From: [Dan Grove](#)
To: [Molly McGuire](#)
Subject: Letter on Permit 2207-019 SUB2 submission
Date: Tuesday, March 7, 2023 9:58:51 AM
Attachments: [For submission - comments on SUB2.pdf](#)

I'm writing to provide additional input on Mercer Island Permit Application 2207-019's recent [submission response memo](#) (SUB2) and corresponding revised [plans](#). On October 25, 2022, I and my attorney, Zach Davison, submitted comments during the public comment period on the initial plan set. This letter supplements those comments in response to the revised plans submitted by the applicant on March 1, 2023.

BASEMENT FLOOR EXCLUSION CALCS:

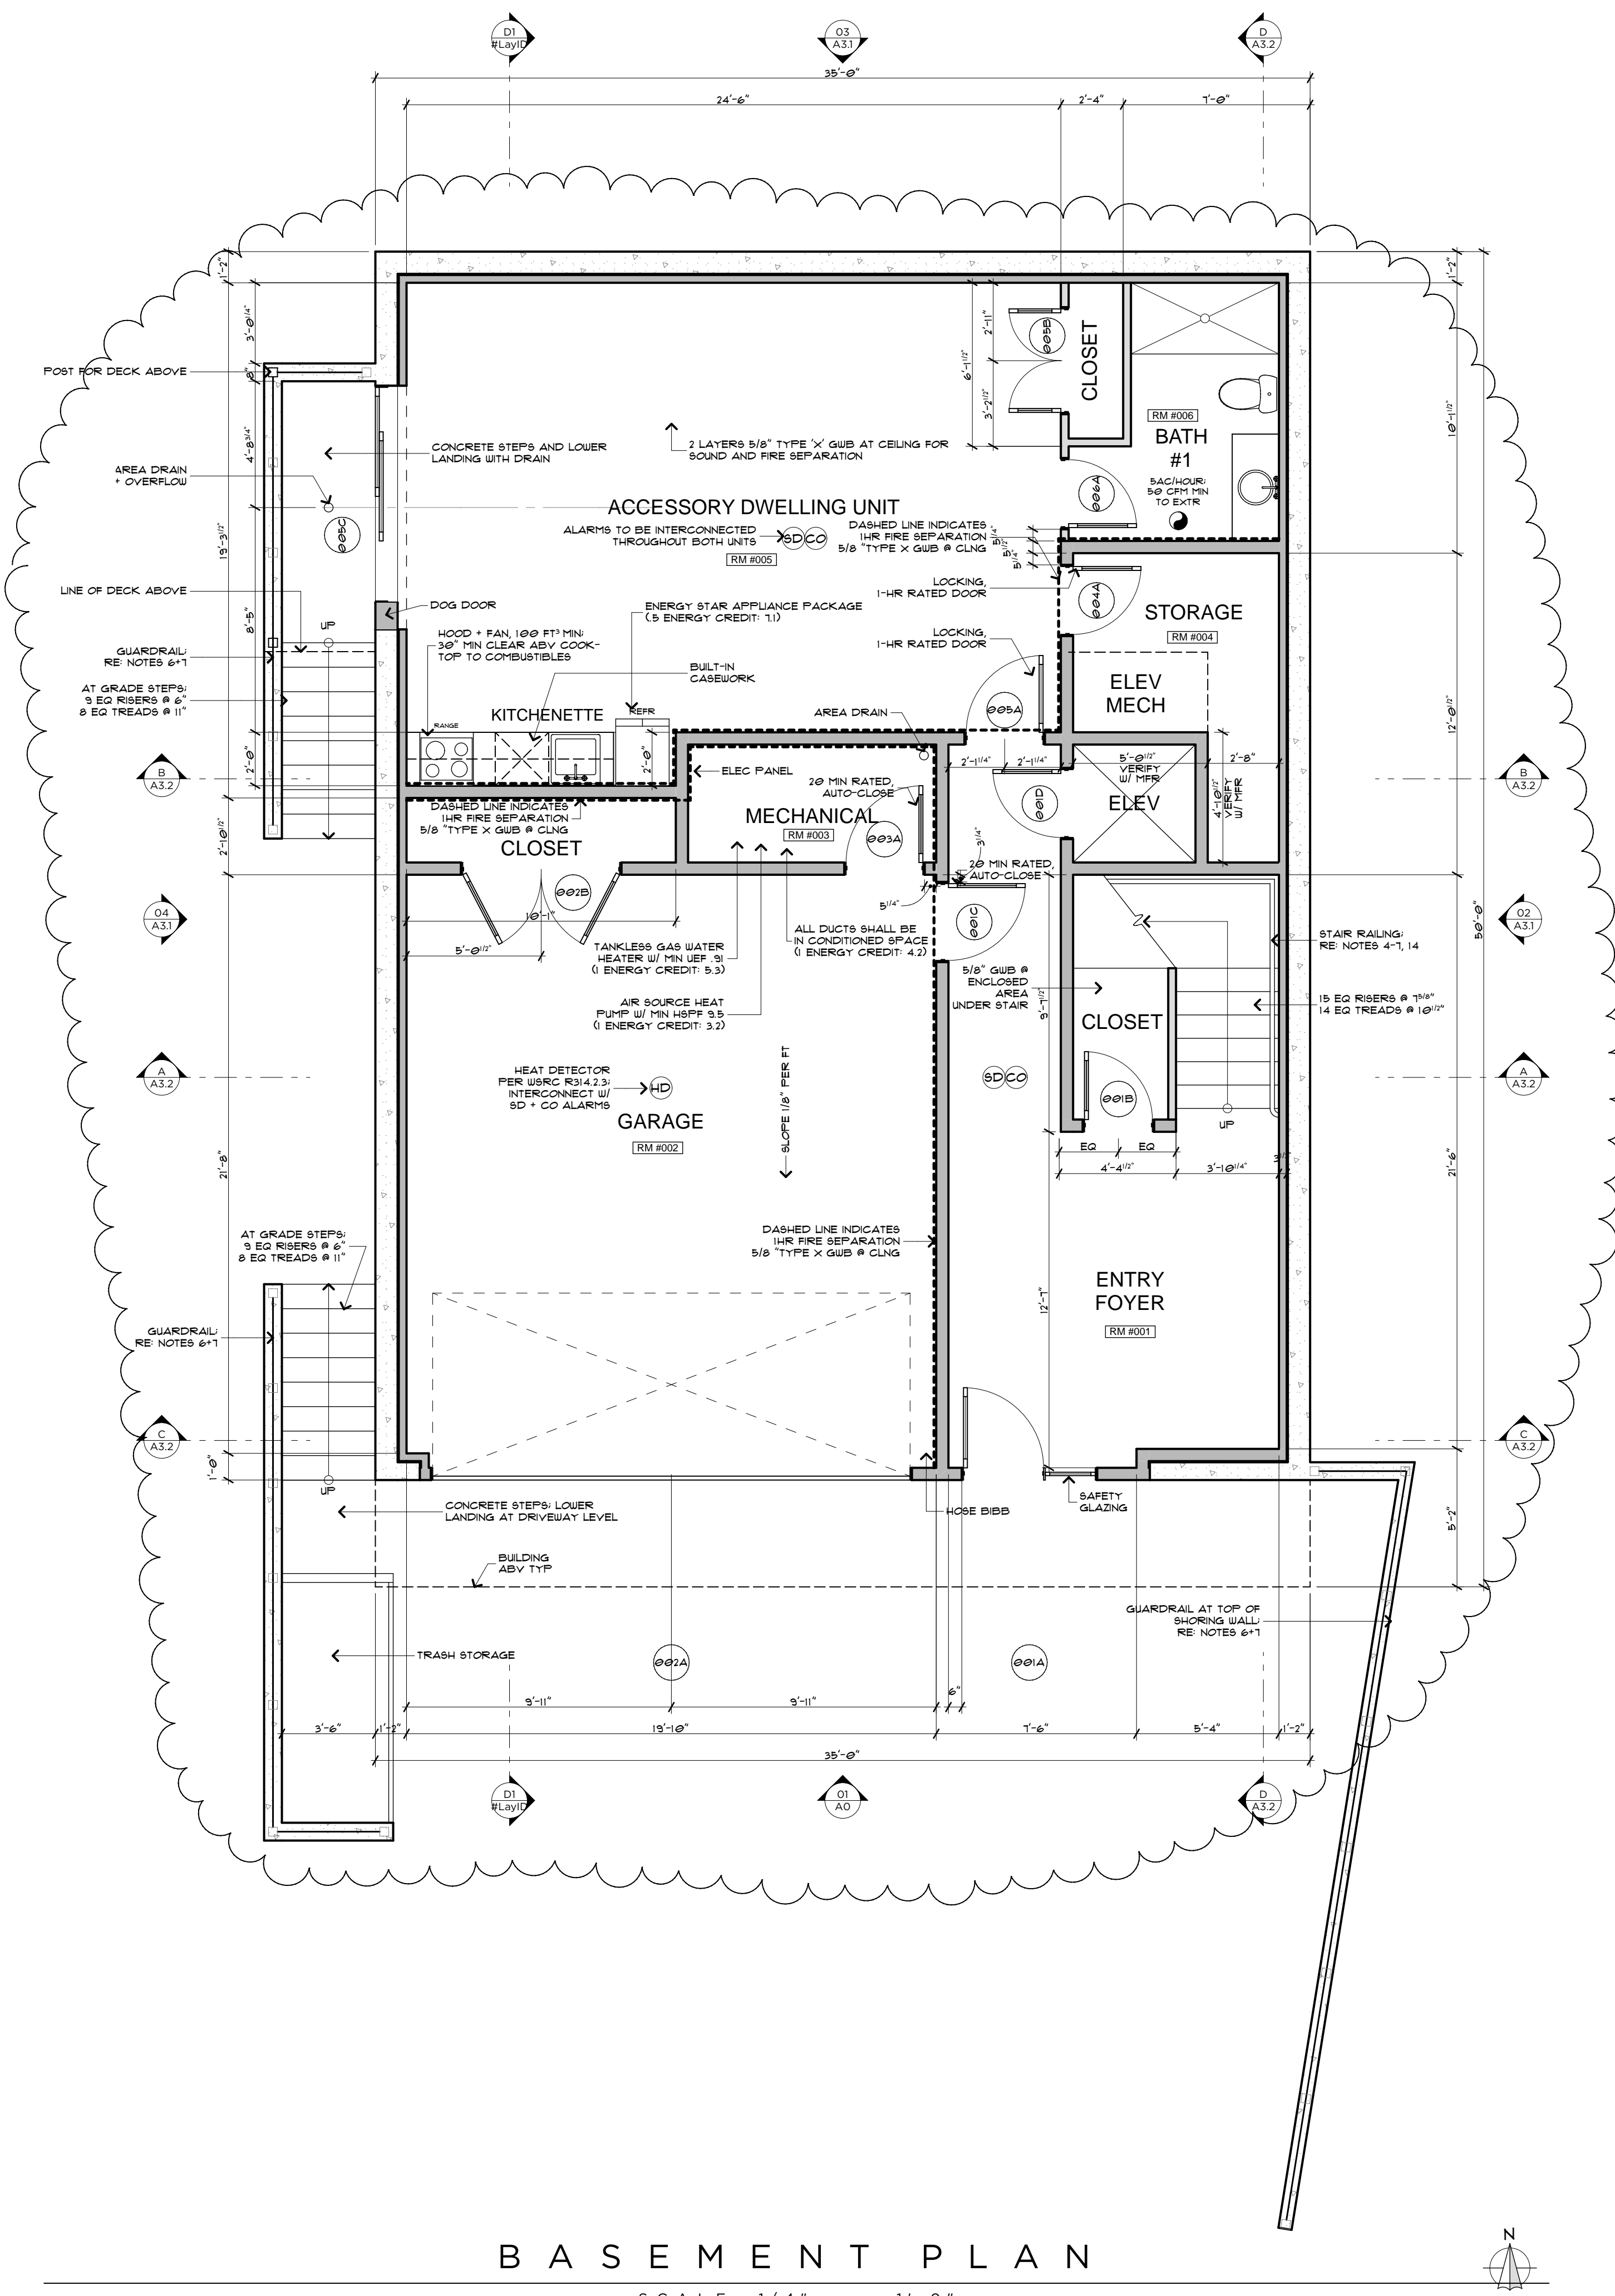
GFA calculations are incorrect. in part, this is because SUB2 computes both Existing Grade and Finished Grade incorrectly.

- West elevation:
 - Covered wall surface at Finished Grade shown in gray, uncovered in red. this shows coverage of ~33% based only on Finished Grade. Precise computation requires clear elevations for the ground floor ceiling and Level 1 FF, which are unavailable.
 - Existing Grade is incorrect, as shown earlier.
 - 2021 Grade appears to be correct.
 - Coverage is incorrectly computed.

- Finished Grade appears correct.
- Existing Grade is incorrect, as shown earlier.
- 2021 Grade does not match SUB2. The blue area below shows the actual exposed wall in 2021, because part of this wall sits on top of an existing basement.
- Coverage is incorrectly computed.

- Finished Grade appears correct.
- Existing Grade is incorrect, as shown earlier.
- 2021 Grade does not match SUB2. The blue area below shows the actual exposed wall in 2021, because part of this wall sits on top of an existing basement.

- Coverage is incorrectly computed.

As a result of these errors, the Basement Exclusion is incorrectly computed. The incorrect Basement Exclusion contributes to errors in the GFA.

The proposed ADU is approximately 600 square feet, with claimed coverage of the basement is 58.2% (as a result, the ADU is only using net ~250 square feet [$\sim 600 * (1 - .582)$] in the design). An accessory dwelling unit may not be used to increase the GFA of the remainder of the proposal (MICC 19.2.020.D.3.b).
